KIRKLEES METROPOLITAN COUNCIL INVESTMENT & REGENERATION SERVICE

DELEGATED DECISION TO DETERMINE PLANNING APPLICATIONS

Reference No:	2026/62/90193/E
Site Address:	Land adj, 1a, Field Head, Shepley, Huddersfield, HD8 8DR
Description:	Demolition of existing barn and erection of two dwellings
Recommending Officer:	Danielle Cooper

DECISION – CONDITIONAL FULL PERMISSION

second floor

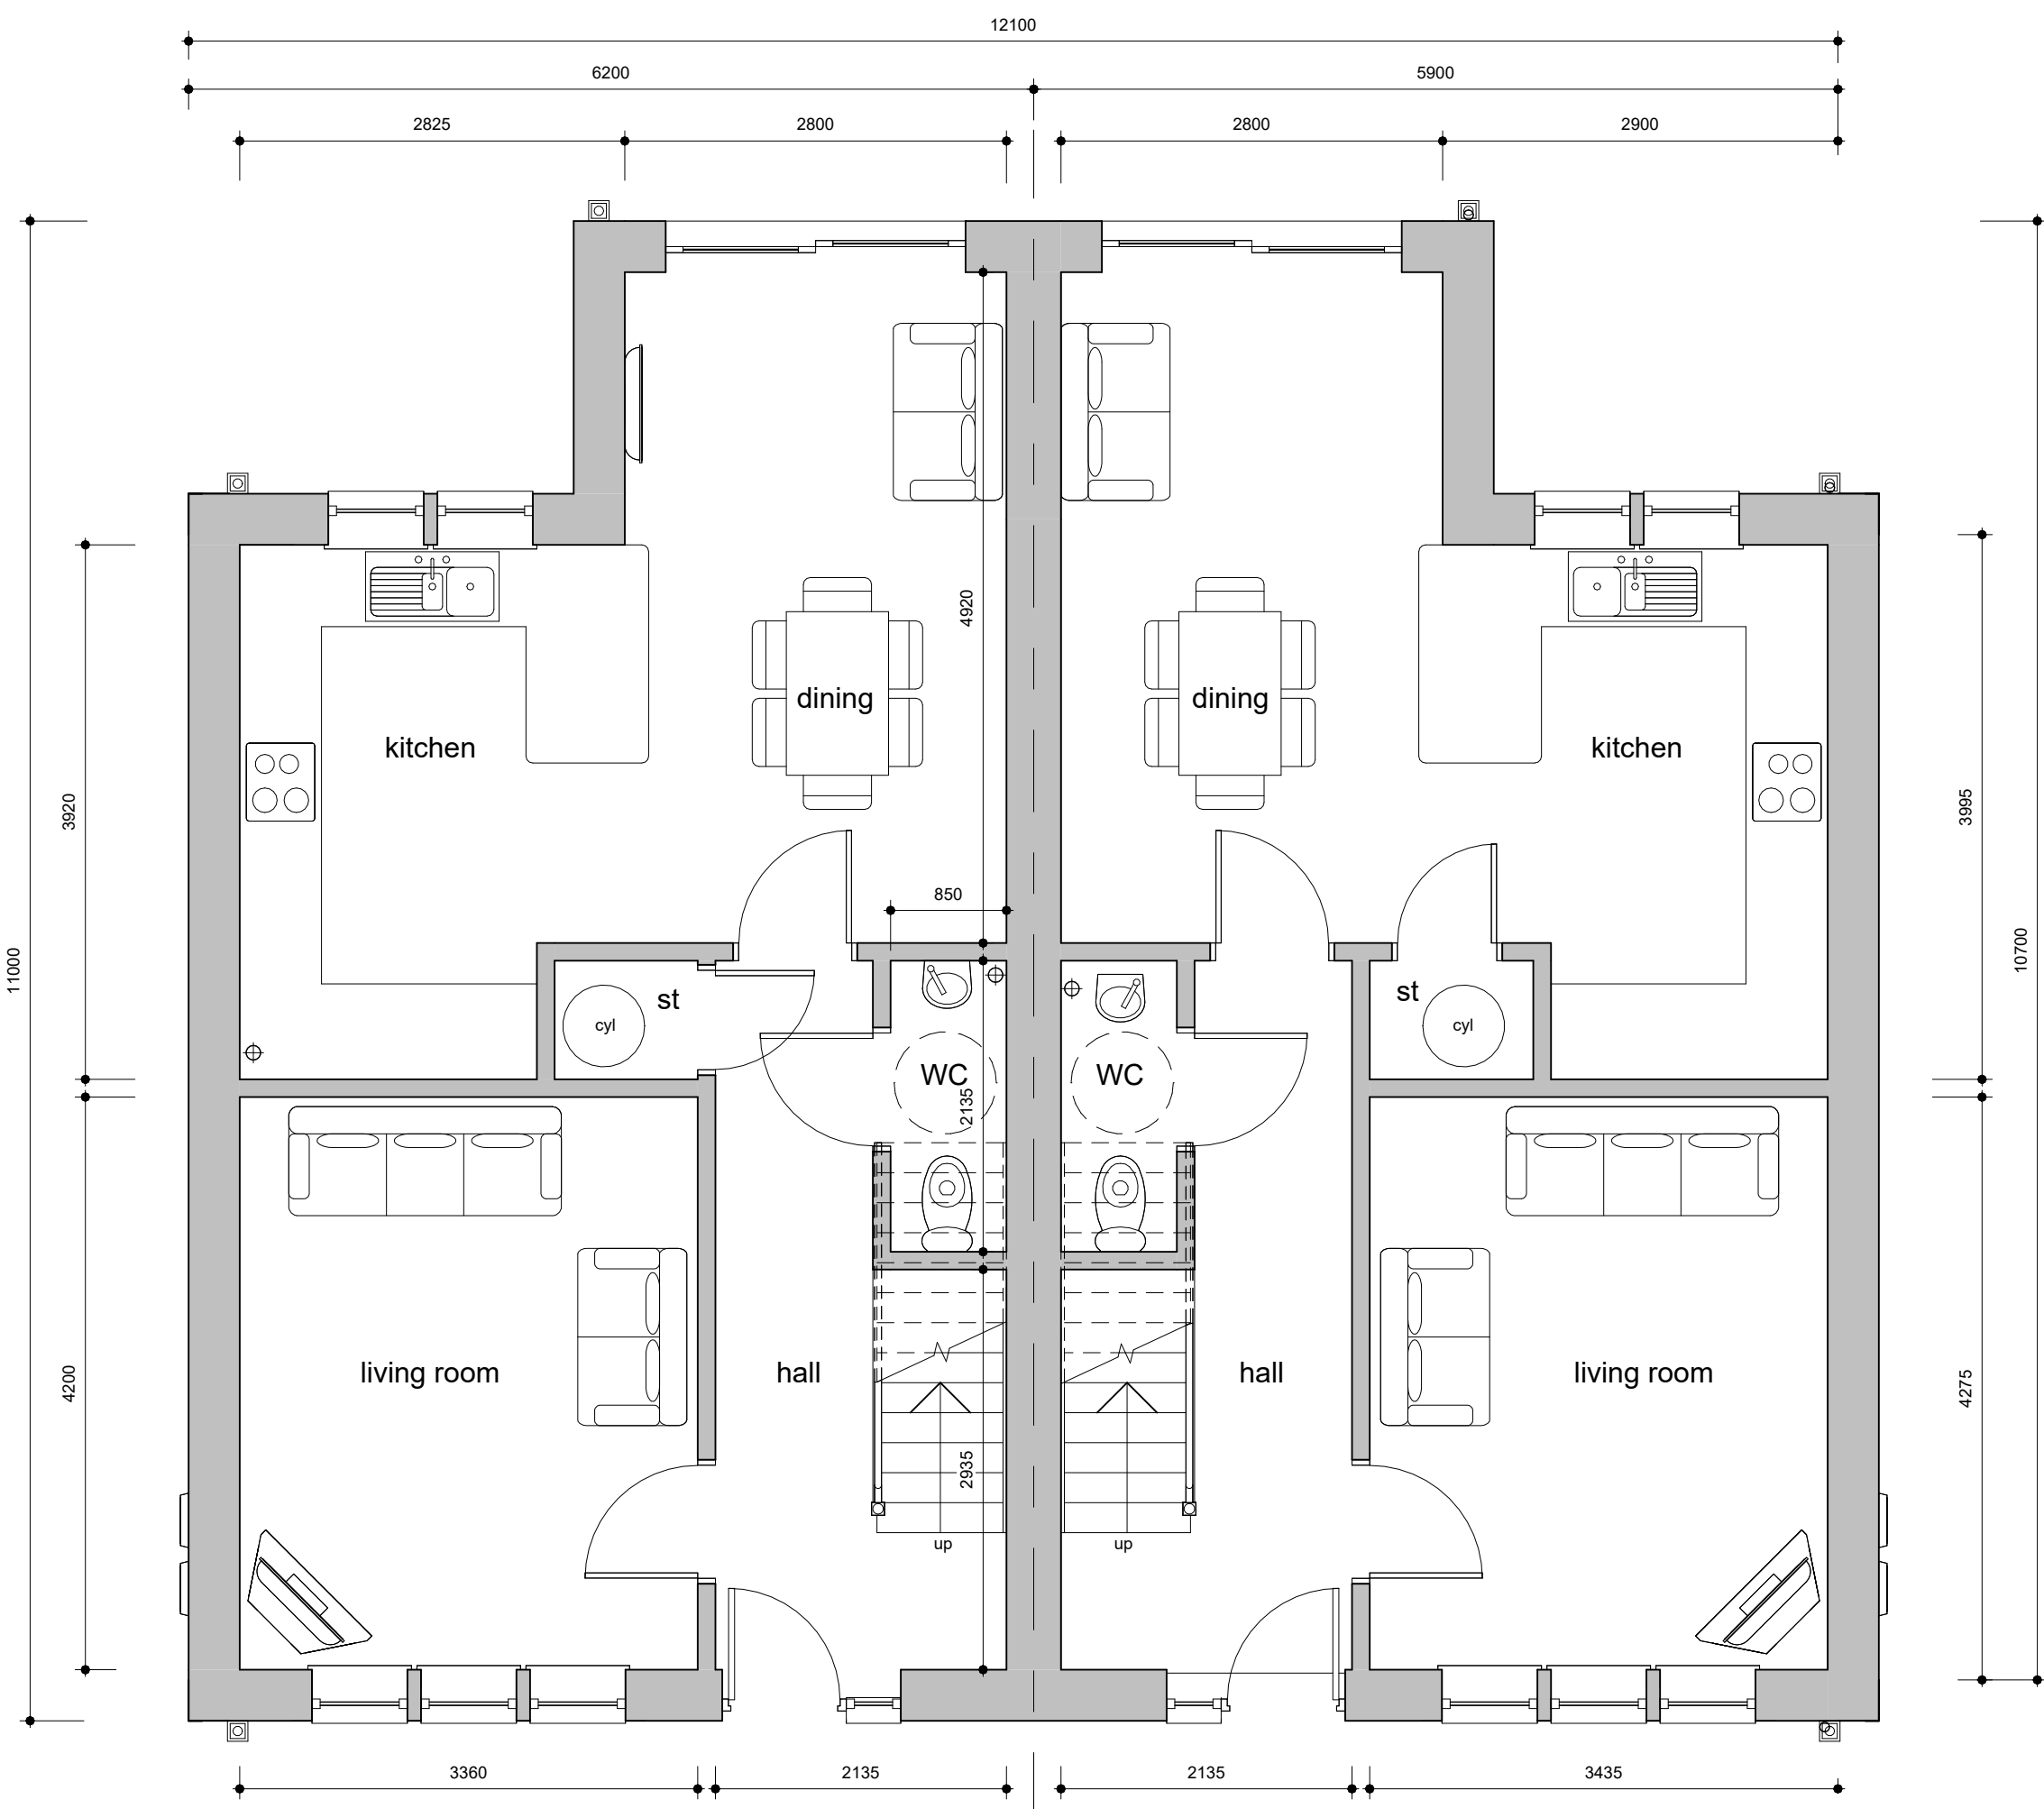
The proposal includes two first floor side windows facing No.1a. One of the first floor side windows would serve a bathroom. As this window relates to a non-habitable room, there are no concerns regarding loss of privacy for the occupants of No. 1a Field Head. The other first floor side window would serve a study. As this window would look directly provide views across the roof of No. 1a Field Head which is a bungalow, there are no concerns to loss of privacy.

The proposal includes two first floor side-facing windows which face towards Nos. 36a and 36b Station Road and 1a Lydgate Road. One of these windows would serve a bathroom, which is a non-habitable room, and therefore it is not considered to give rise to any unacceptable overlooking or loss of privacy for the occupants of the neighbouring properties. The second first-floor side window would serve a study and would provide views towards Nos. 36a and 36b Station Road and 1a Lydgate Road. Whilst it is acknowledged that the separation distance between this window and the neighbouring properties would be approximately 17 metres, falling below the recommended 21-metre distance, the shortfall is considered relatively minor. Given the limited degree of harm identified, it is not considered that the proposal would result in a significant loss of privacy or overlooking sufficient to warrant refusal of the application. The impact is therefore considered acceptable.

| P02  | Amended first floor bedroom and study | 30.06.26 | JW    | NG       |

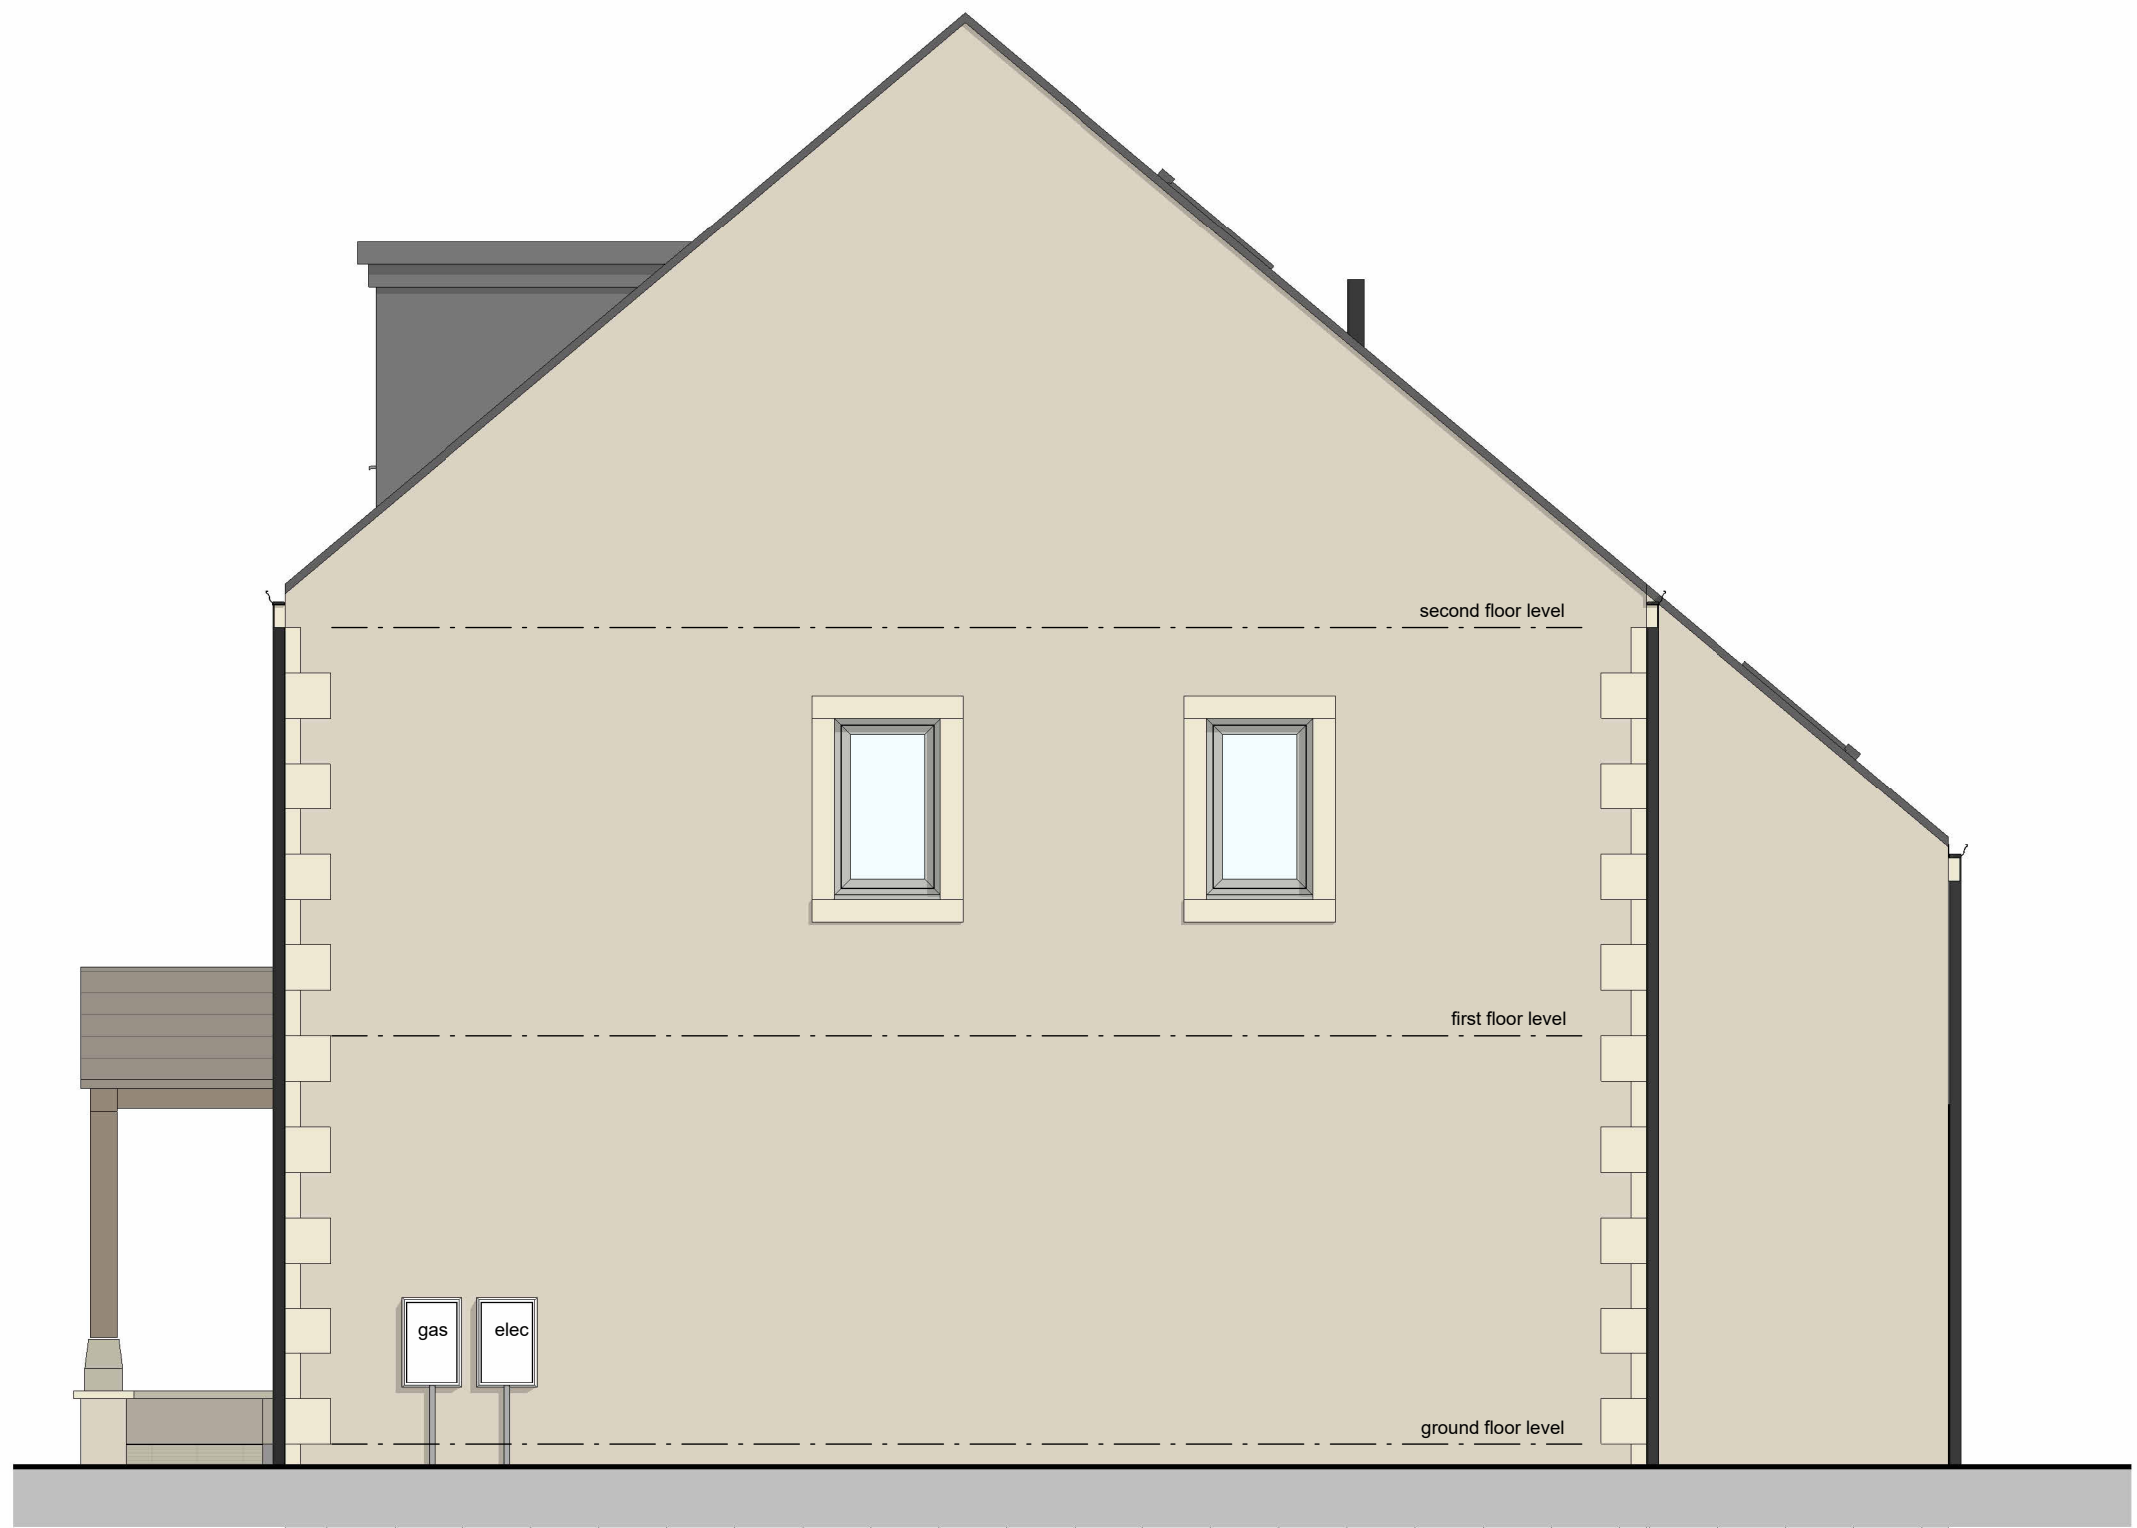
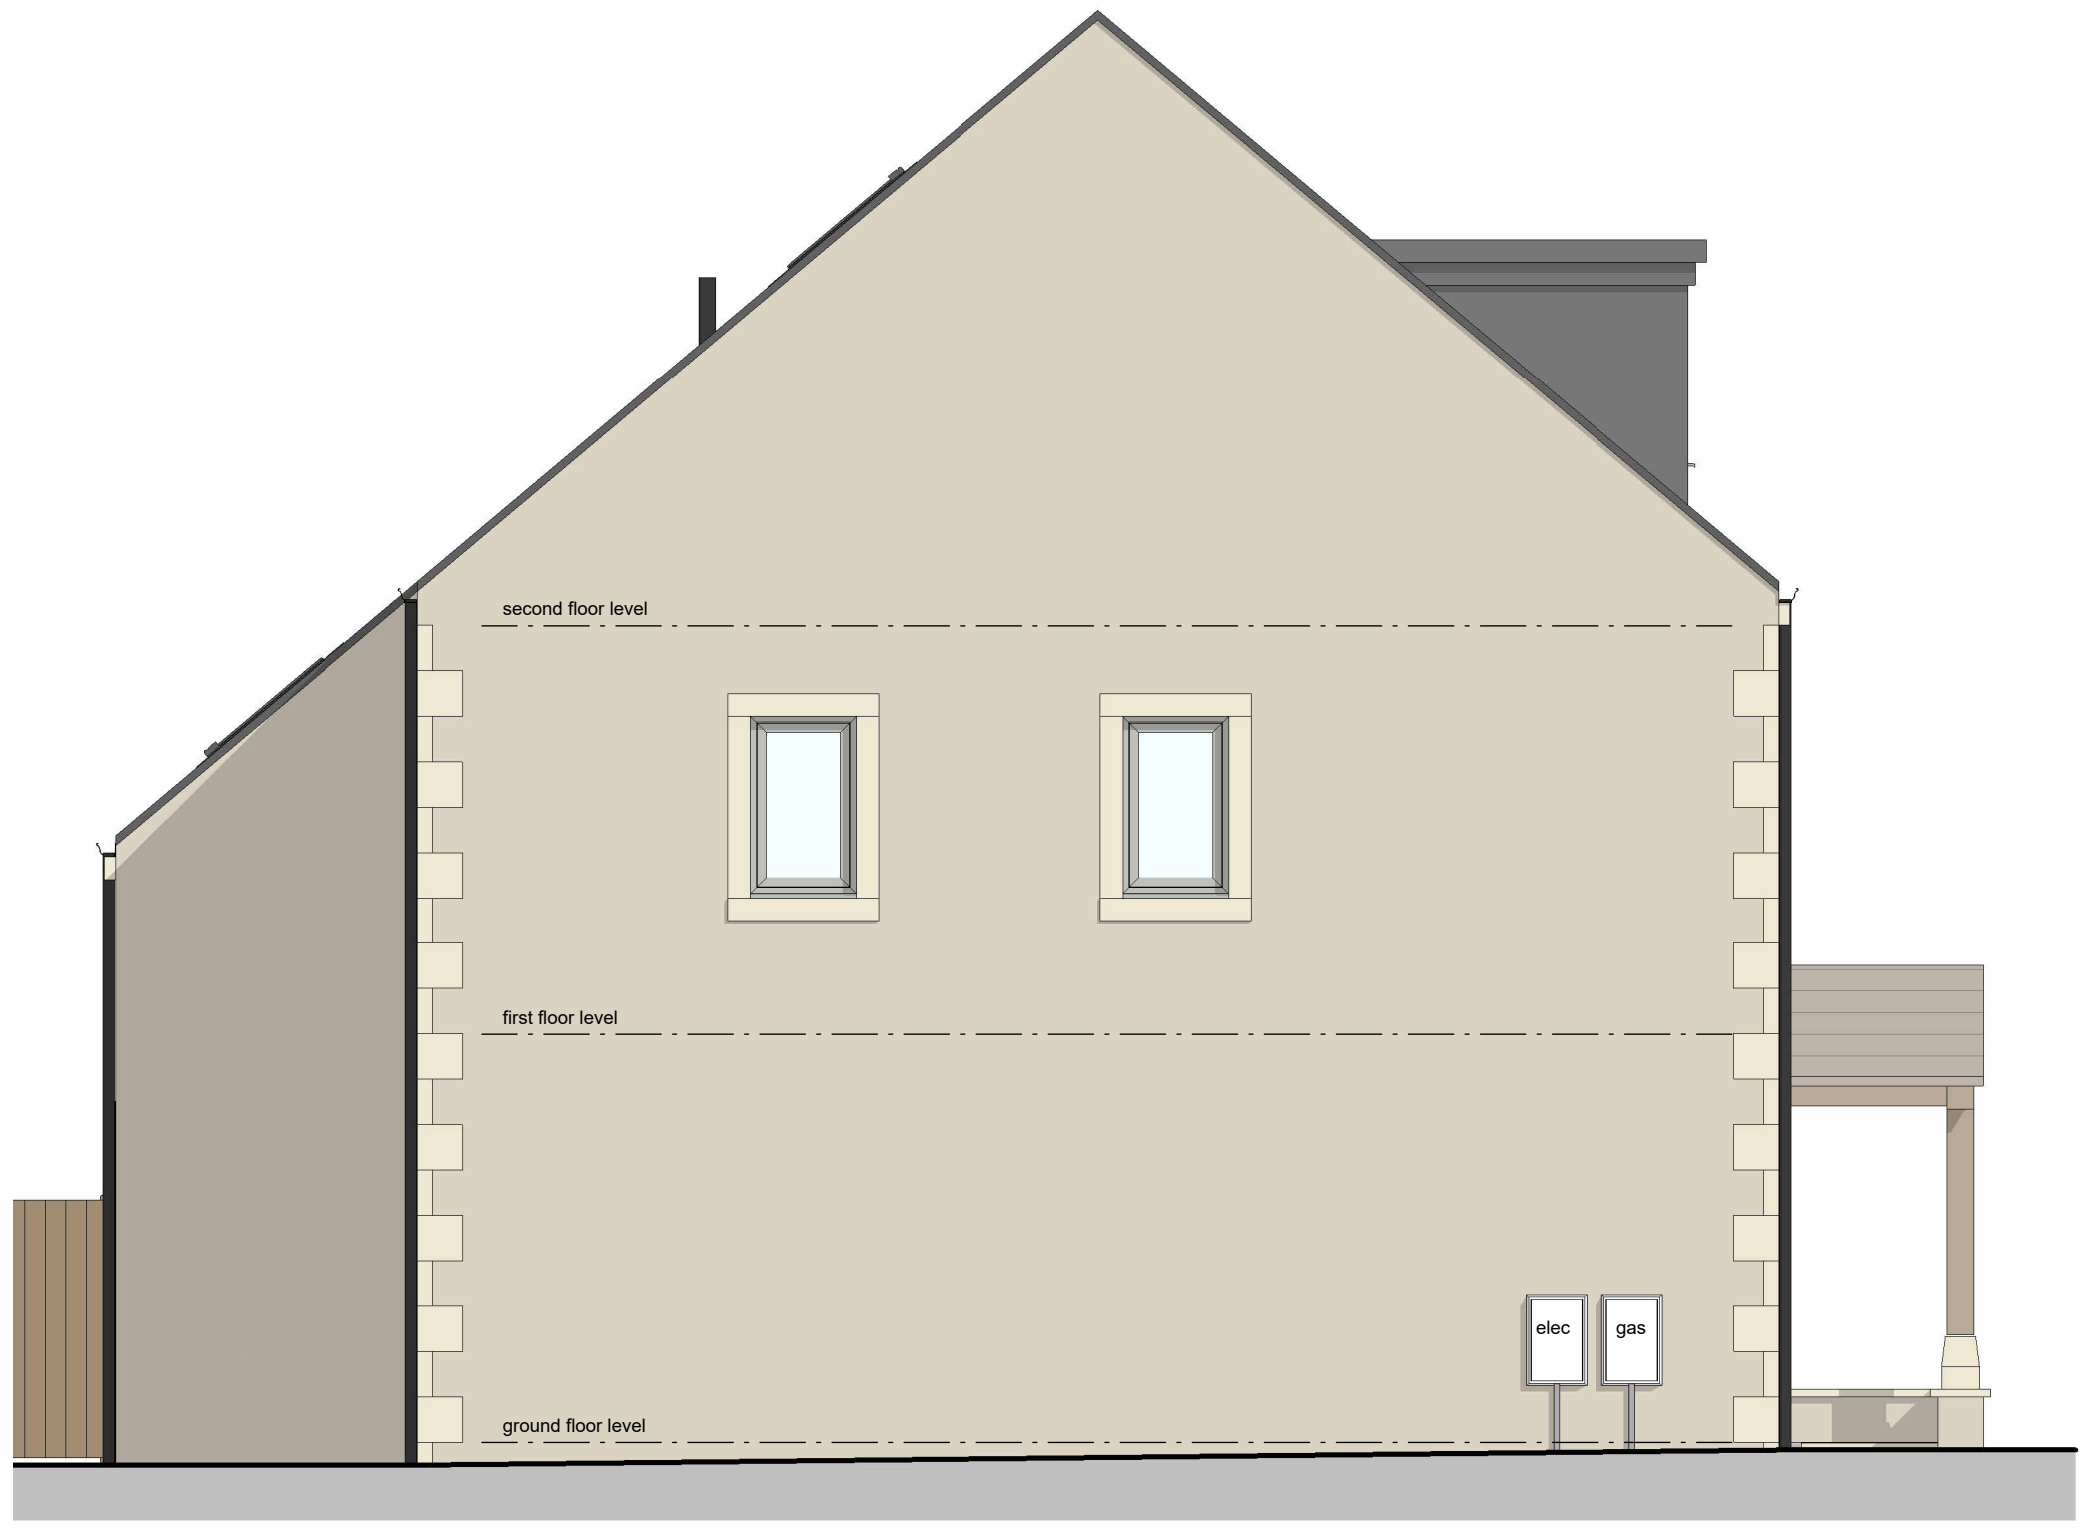
The scheme has been revised during the course of the application to address potential privacy concerns arising from the three side-facing windows at No. 57. The proposed ground-floor rear windows are considered acceptable as they will be screened by the proposed 1.8m high hedging along the rear boundary, thereby preventing any undue loss of privacy. To ensure the effectiveness of these measures, a condition is recommended requiring details of all boundary treatments, including specifications of the proposed hedging and elevation drawings confirming its height.

The proposed first-floor study windows are annotated as obscure glazed in order to mitigate any potential overlooking and a condition will be imposed to secure this arrangement. In addition, the proposed bedroom windows will be served by rooflights, which being served by such windows would not have as easily visible outlook to neighbouring occupiers to the north east of the site. As such, the proposal is not considered to result in any unacceptable impacts on the privacy or amenity of neighbouring occupiers.

4. The development shall not be occupied until the rear windows serving the room annotated as 'study' upon submitted drawing ref: 25060D-03-P04 have been fitted with obscure glazing or permanently affixed film which achieves an obscurity of Pilkington level of four or equivalent. Notwithstanding the provisions of the Town and Country Planning (General Permitted Development) Order 2015 as amended (or any Order revoking or re-enacting that Order) The obscure glazing or permanently affixed film shall thereafter be retained for the lifetime of the development.
